From: Archaeology <Archaeology@lancashire.gov.uk>
Sent: 16 July 2021 15:40
To: Carly Miskell; Planning
Subject: RE: Consultation on Discharge of Condition, 3/2021/0705, 20-22 Talbot St Chipping PR3 2QE

The application is for - Removal of Condition 9 (Photographic Recording) of Listed Building Consent application 3/2020/0763.

Figure 2: W1, photograph points

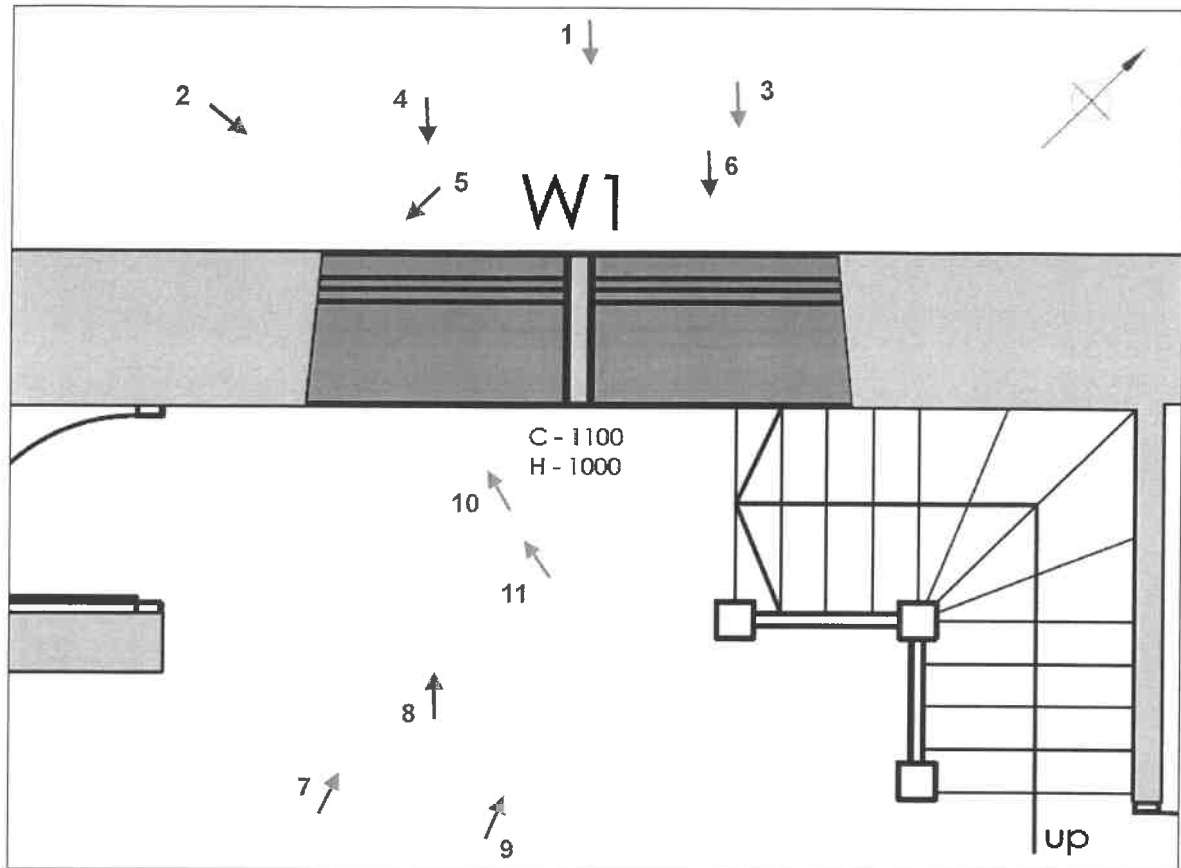
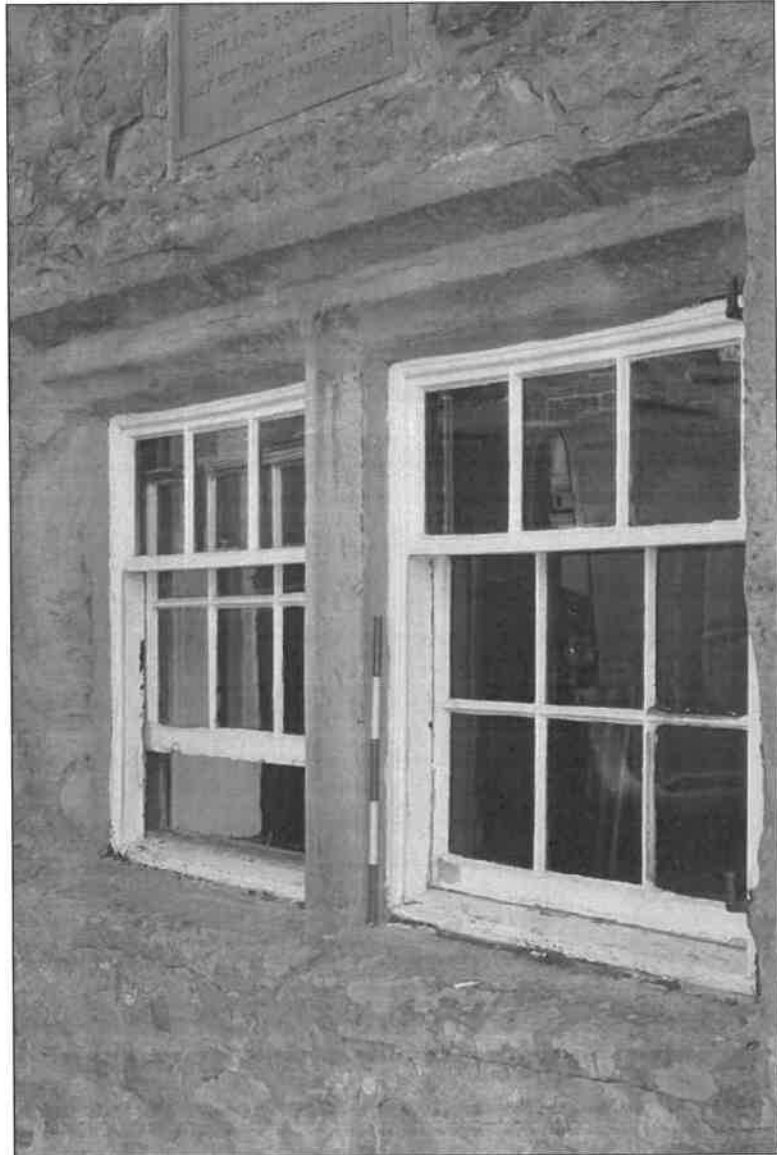
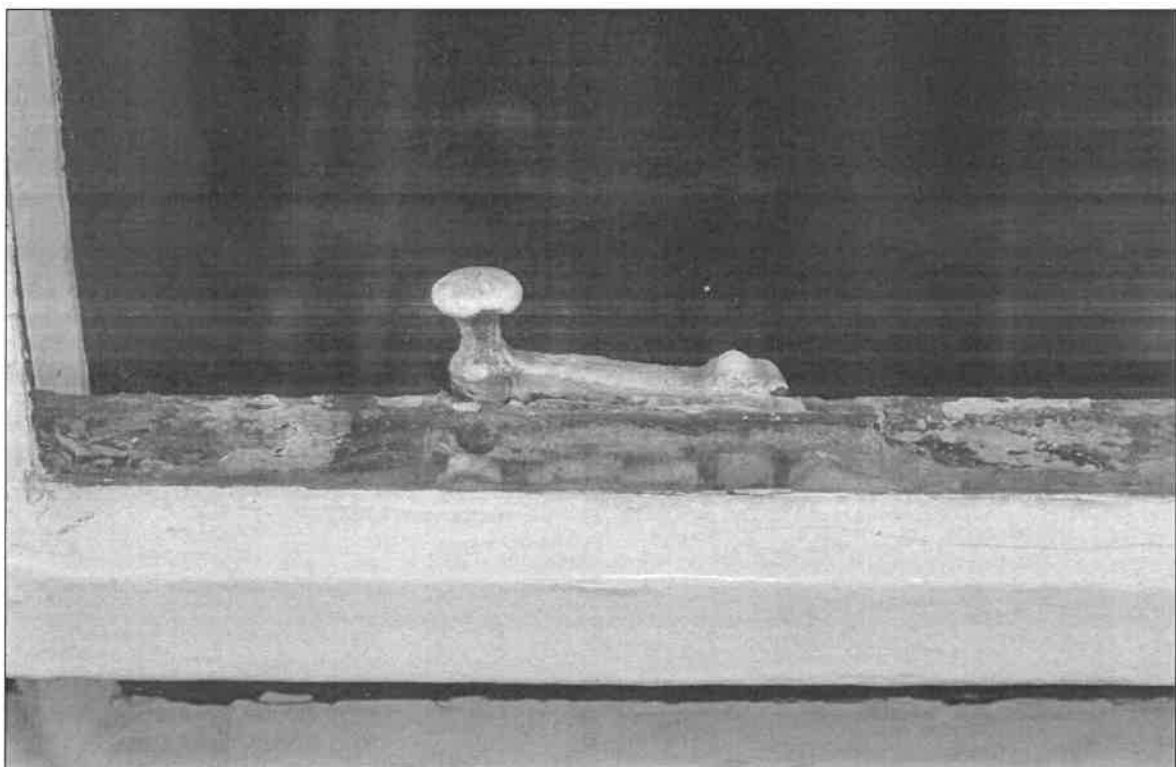
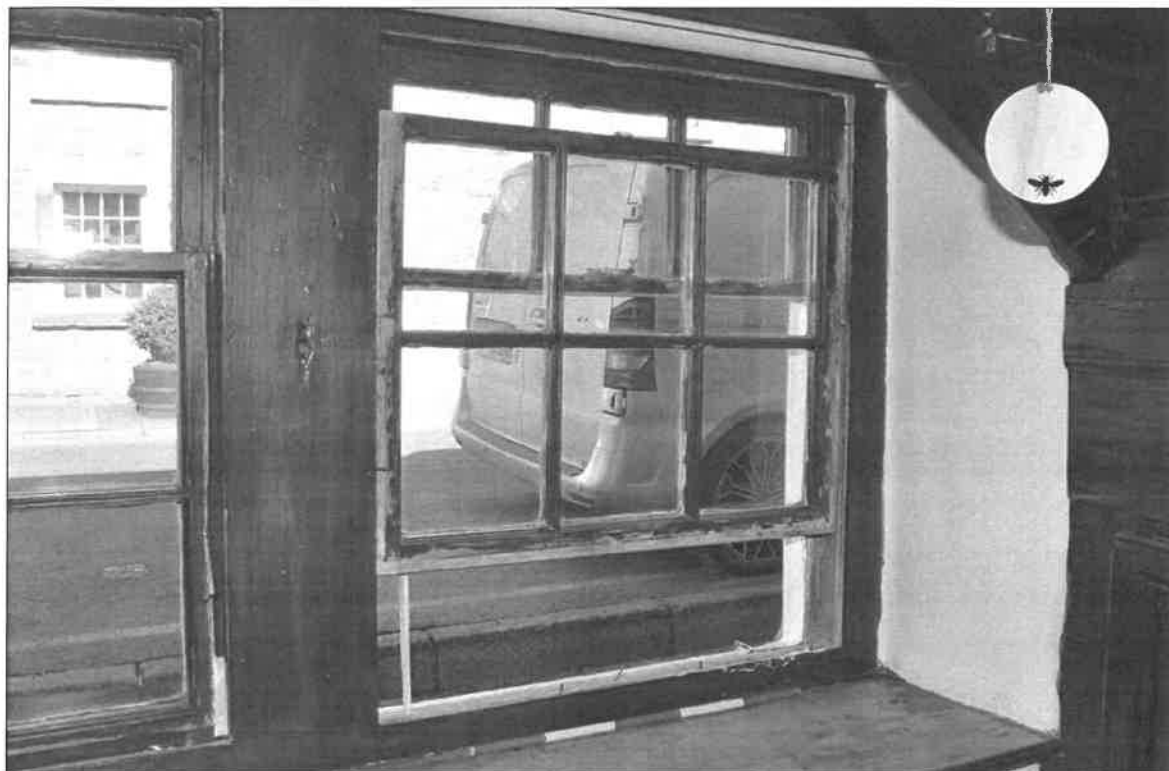
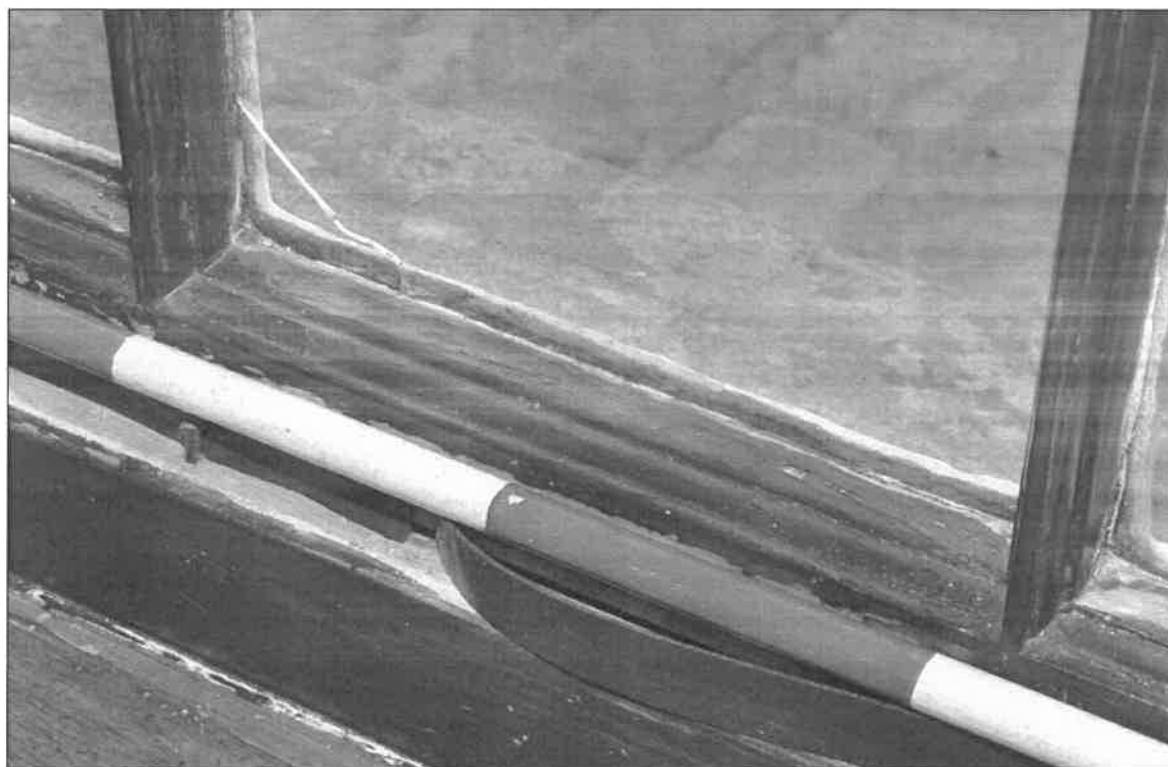
Thank you for your consultation on the above application. As you will be aware we did not request that the recording scheme include the windows, although it appears to have been a useful exercise. The only addition to the record we could suggest is the provision of a 1:1 section drawing of typical glazing bars from windows W1 and W2, but you may consider that this is unnecessary.
